From: [Zach Torrance-Smith](mailto:Zach.Torrance-Smith)
To: smithwr19@gmail.com; dpierce@encompasses.net
Cc: [Jamey Ayling](mailto:Jamey.Ayling)
Subject: BL-23-00019 Smith
Date: Wednesday, September 13, 2023 3:04:34 PM

We are processing your Boundary Line Adjustment and we are going to need some additional materials added to your site plan in order to be able to deem your application “complete” and move forward with the process of reviewing it with other departments.

**PRELIMINARY BOUNDARY LINE ADJUSTMENT**

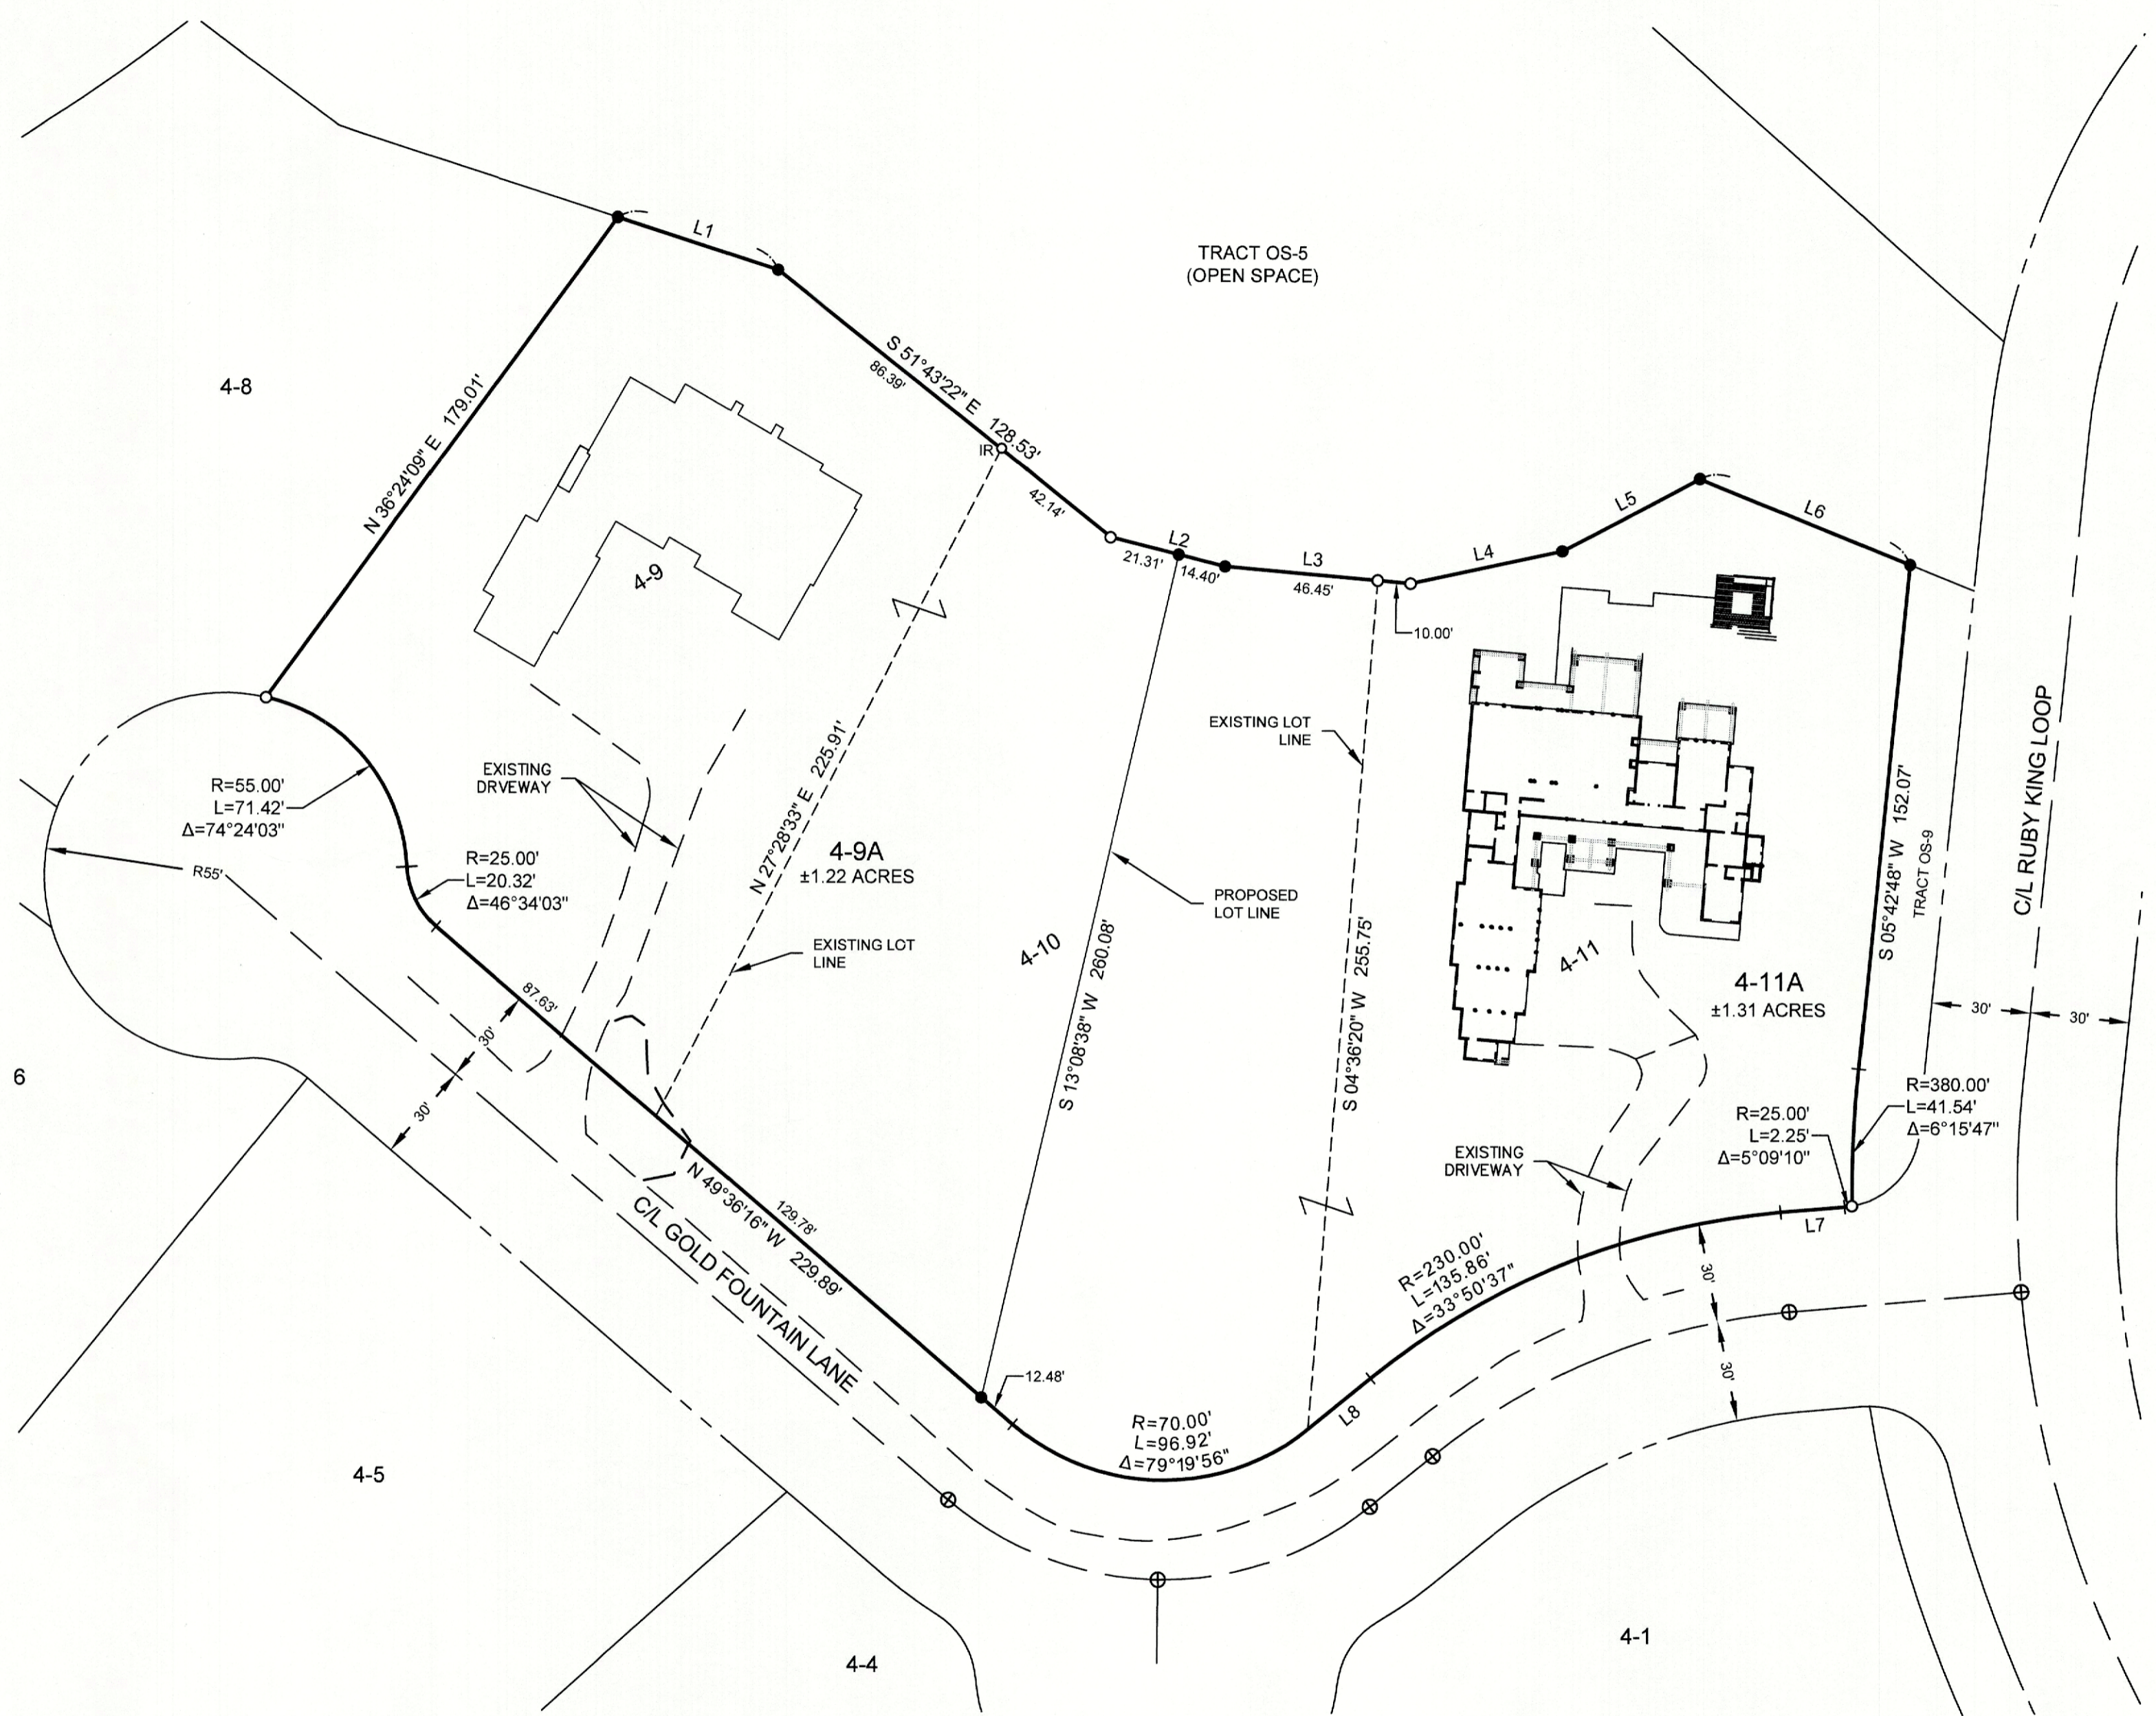
Please add the following elements to your site plan:

- Distances to proposed boundary lines from all existing structures.
- Well heads and septic systems/drainfields also need to be represented on the map.
